Our Ref: BN/160/21/NMA

Non material amendment following the grant of BN/39/20/PL for Plot 1 (internal amendments not impacting externally), chimney handed to other side of dwelling & stepped access introduce; Plot 4 (internal amendments not impacting externally) & bulk of dwelling handed with chimney moved to external wall.

Tars Farm Land at Church Lane Barnham PO22 0DB

04 | Side (South) Elevation  
Scale 1:50 @ A1

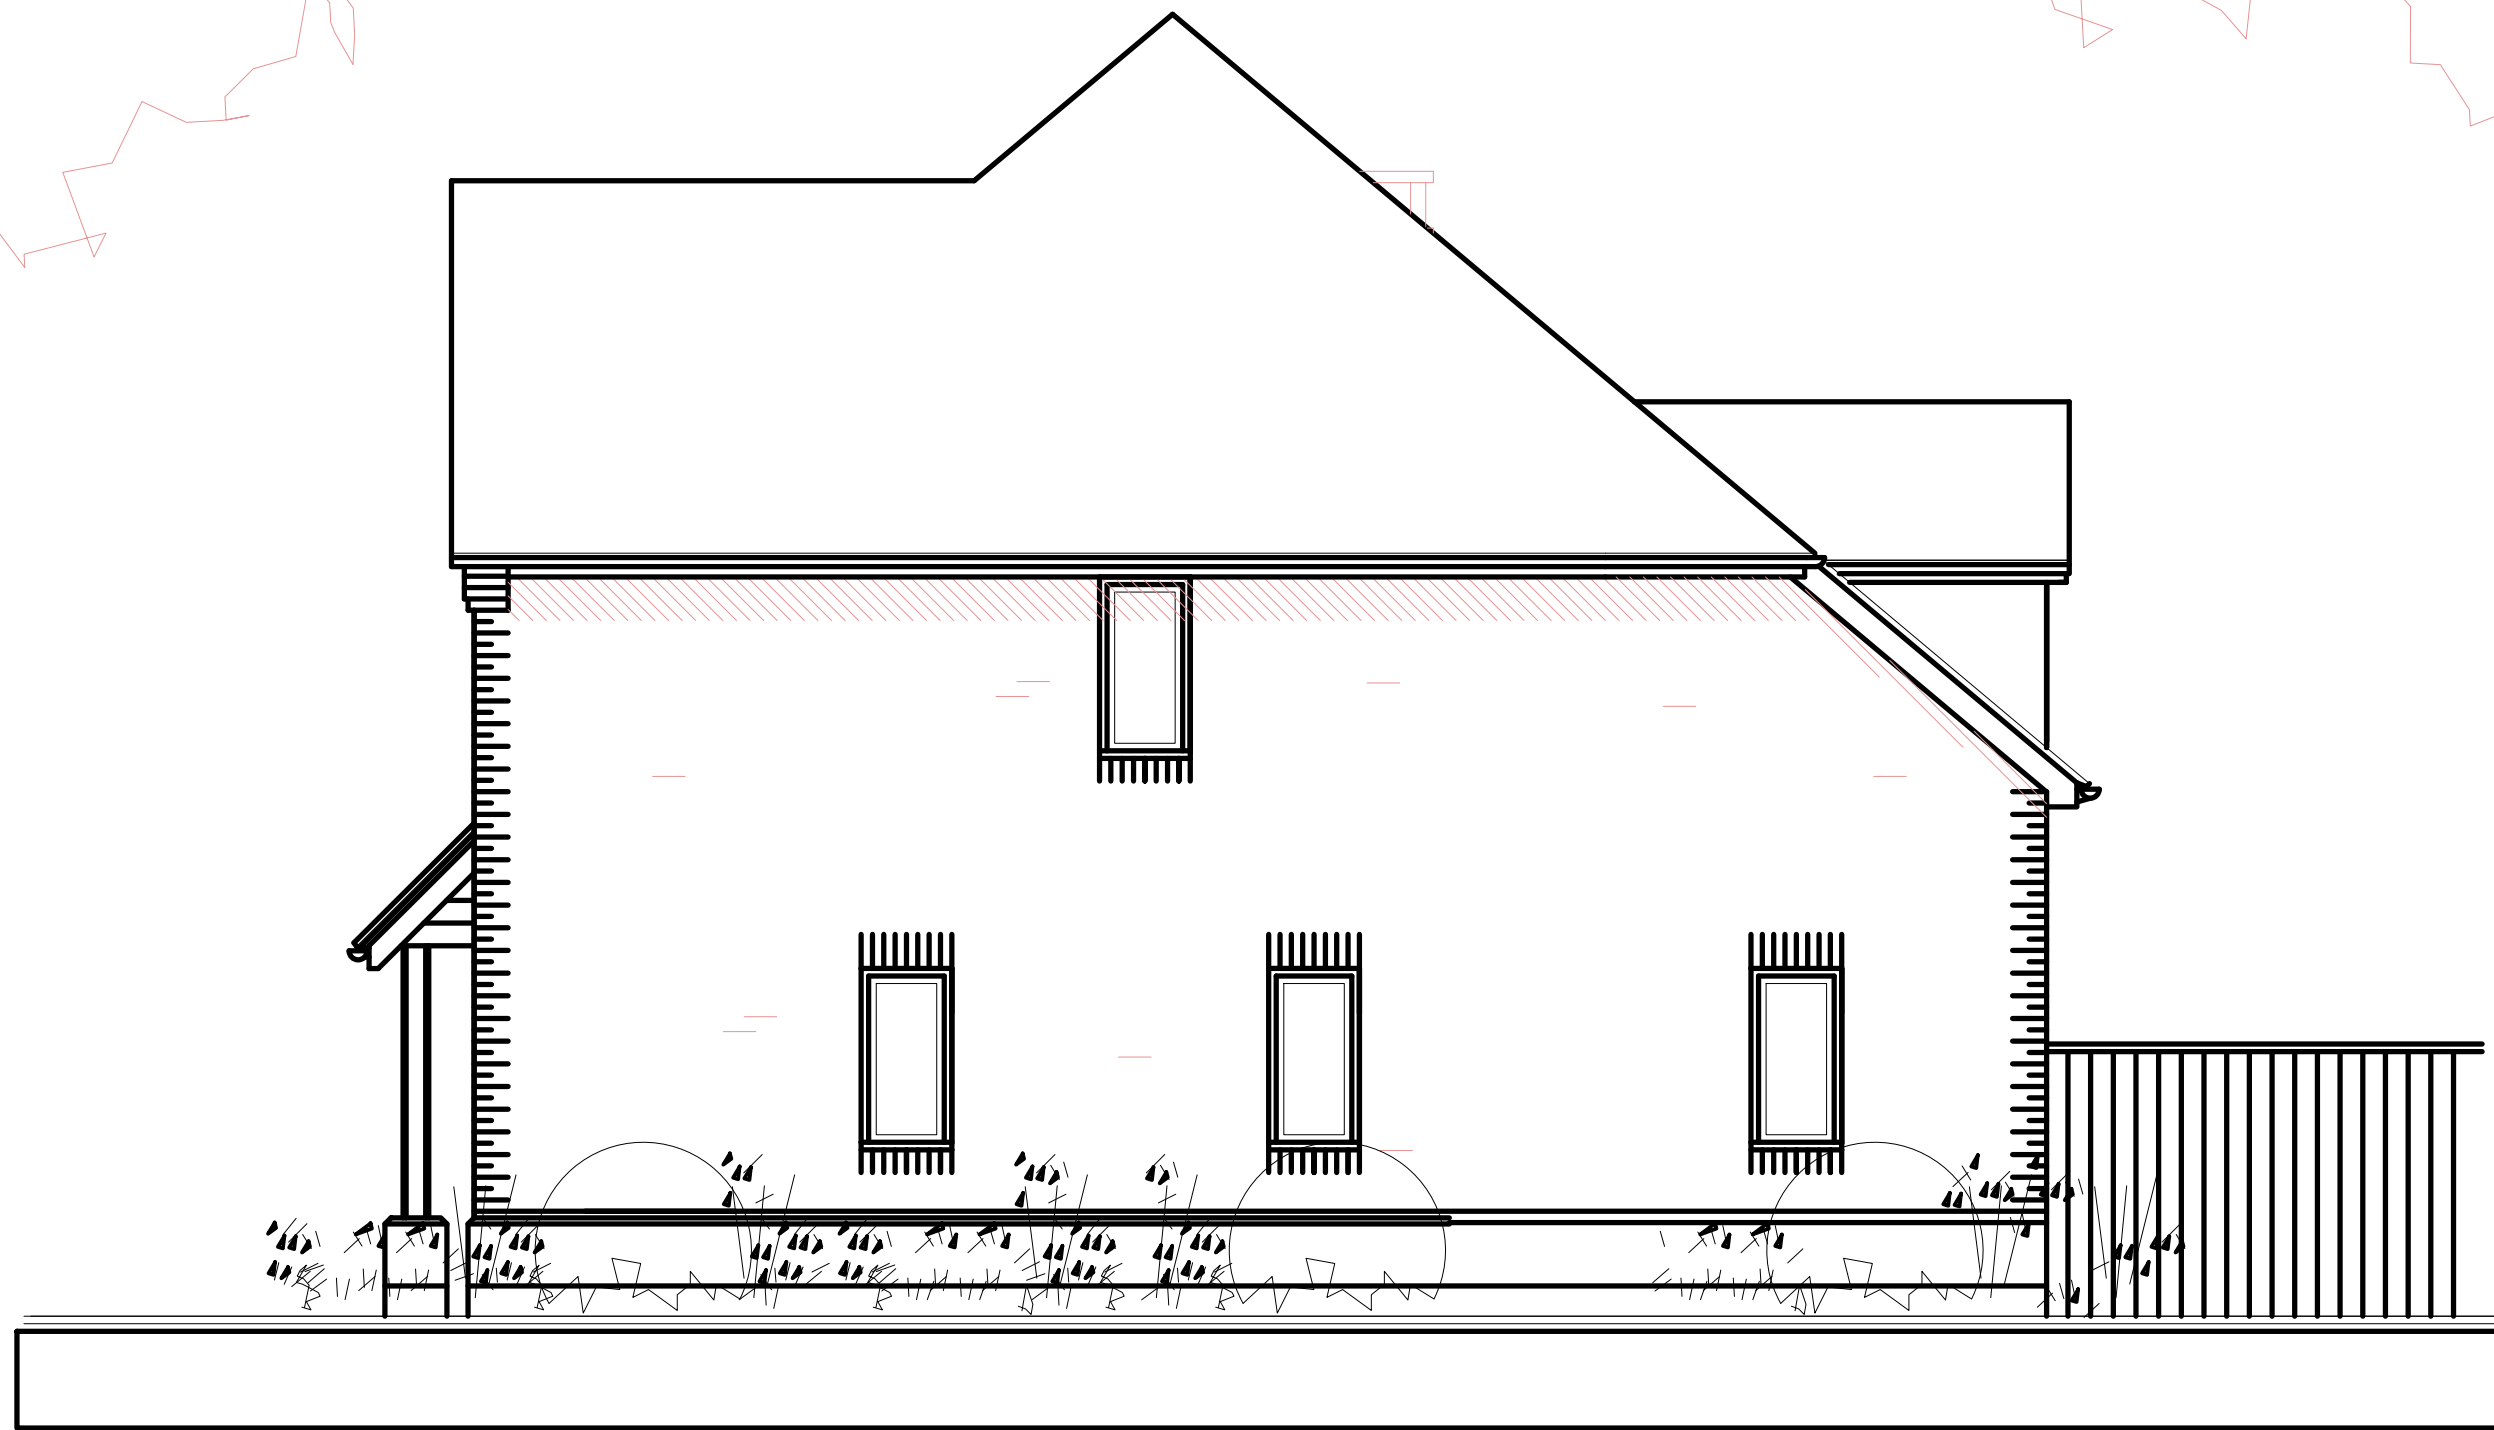
- Plot 1: internal amendments, chimney handed from the north to the south flank elevation, introduction of stepped access to the front door & north facing ground floor door removed; and
- Plot 4: internal amendments, ground floor window on rear of attached garage moved and door introduced, chimney stack introduced on the west side (relocated from the south facing rear roof slope), ground floor west flank window positions handed and a window to replace a door on the east elevation (ground floor).

These changes will not materially alter the appearance of the development approved by the planning permission, do not conflict with any conditions of the permission, do not breach any planning policy and do not warrant re-consultation. Whilst a new chimney stack on the west elevation of plot 4 is introduced, this is lower than the height of the approved chimney and does not extend further out from the flank wall than the approved bay window on this elevation (and in any case adds less than 1m extra width). All fenestration changes are at ground floor and due to boundary treatments, do not affect neighbouring properties.
